11060 Fontaine Blvd – Grand Mtn School
PPR Amendment – Letter of Intent

March 31, 2026

Address: Grand Mountain School
11060 Fontaine Blvd
Colorado Springs, CO 80925
Zoning: PUD
TSN: 5513301002

SHEET NAME
ENLARGED SITE PLAN
SHEET 2 OF 7

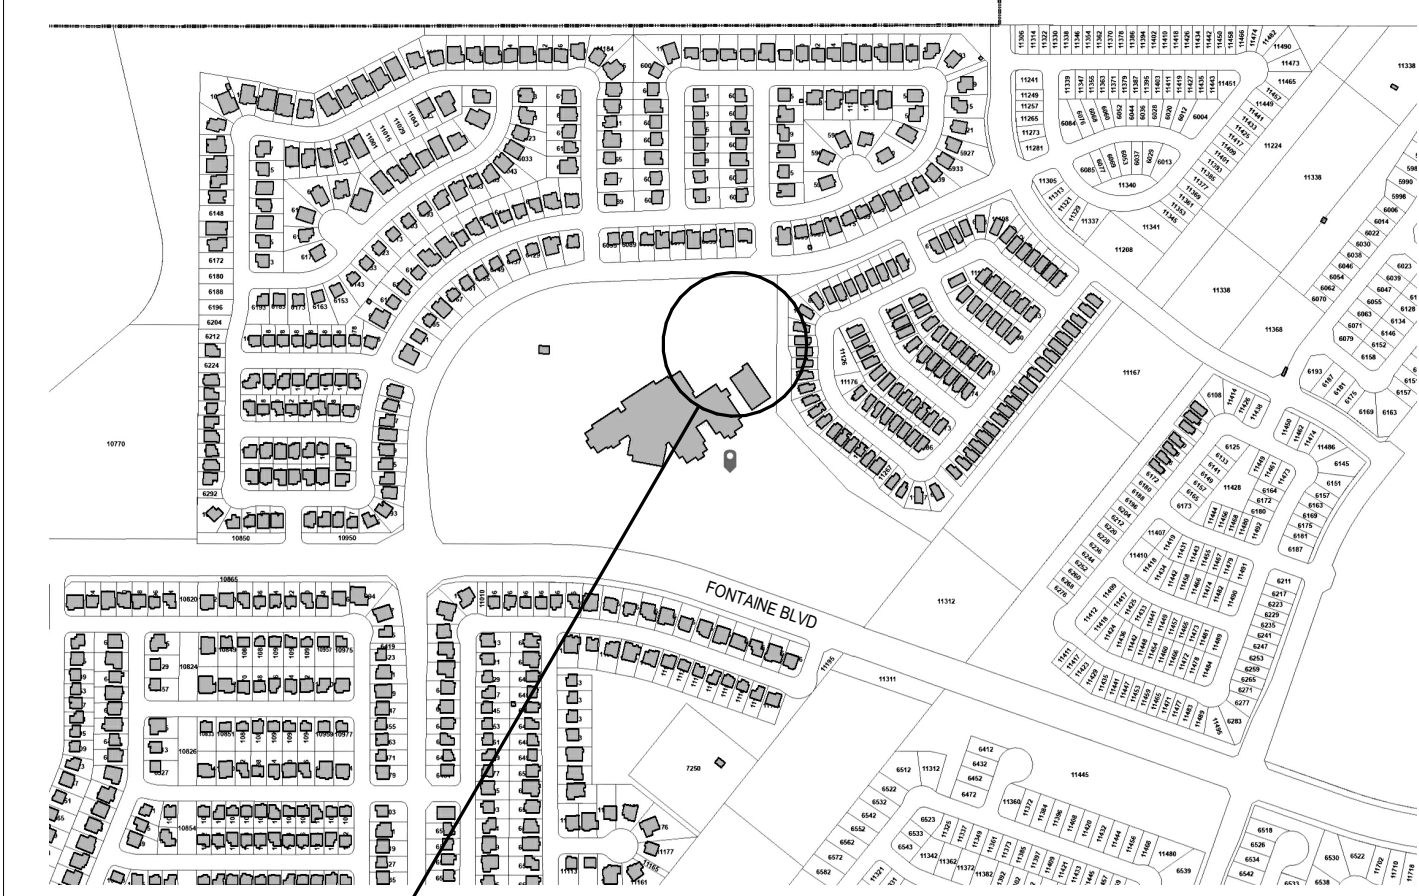
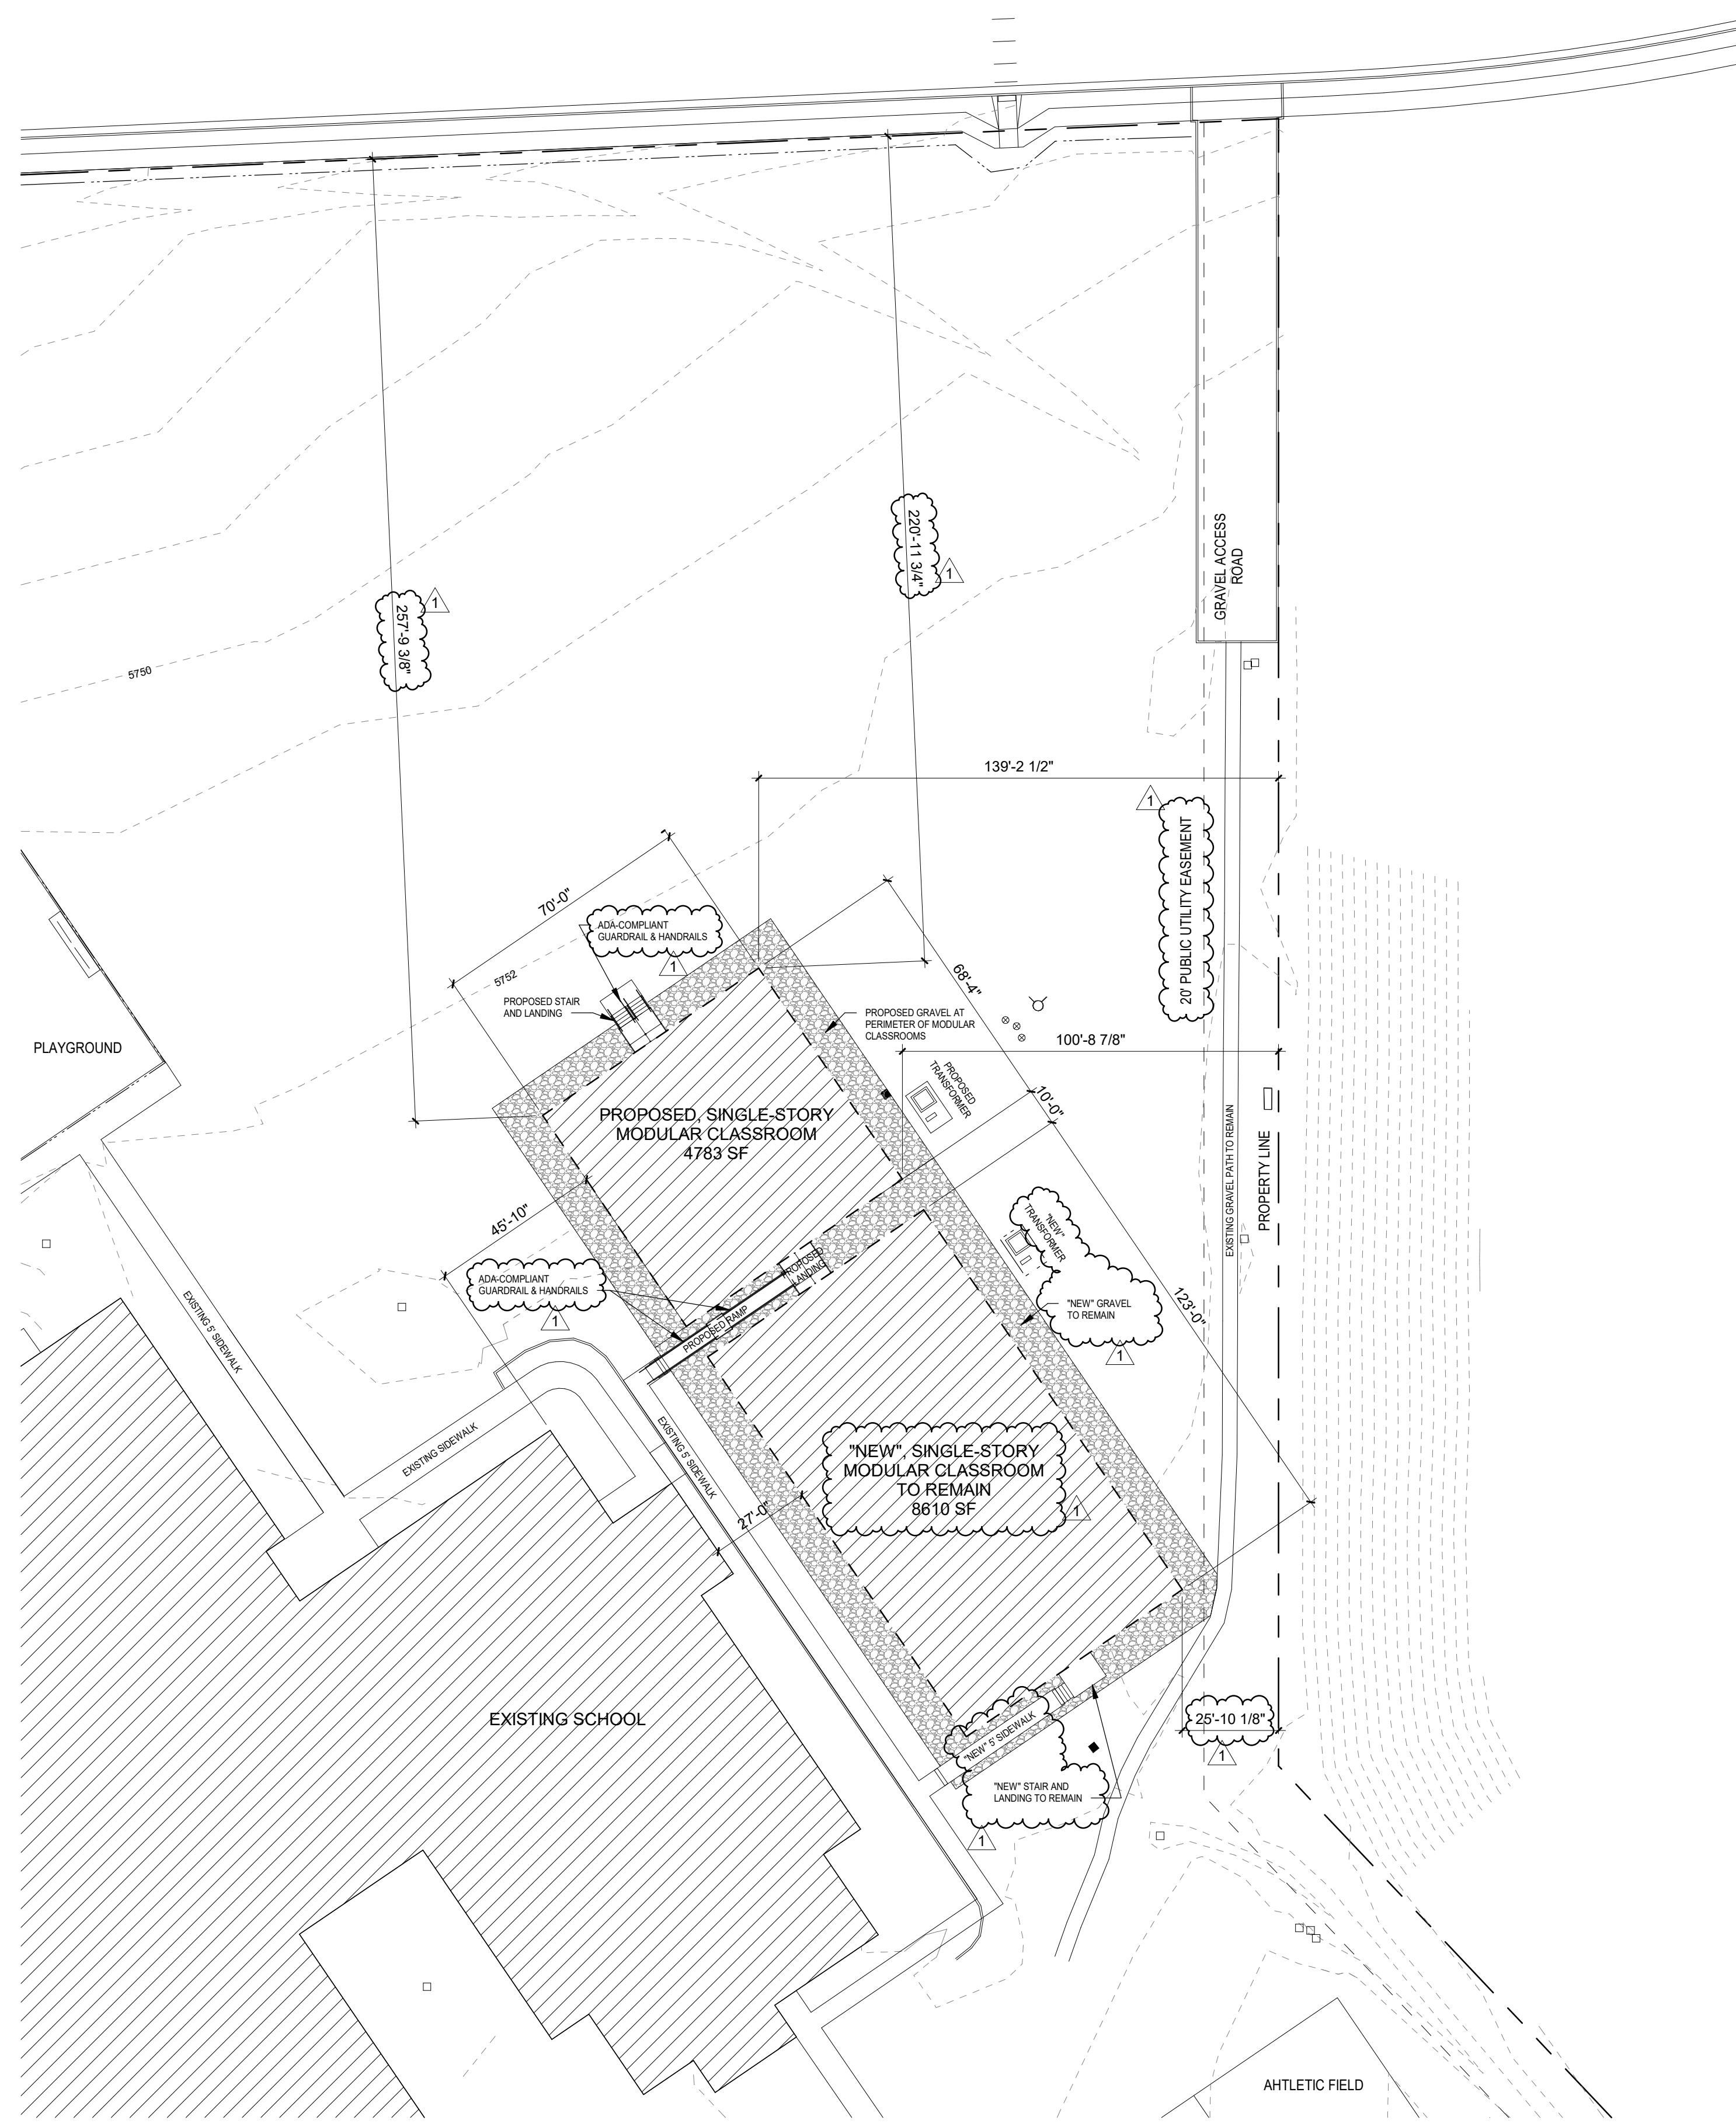
Expand on drainage/storm. Relocated inlet will connect to existing system which releases into existing pond. Ensure release rate is not over existing flows from approved report (See PPR1826 for approved report). Include this in drainage memo requested on site plan.
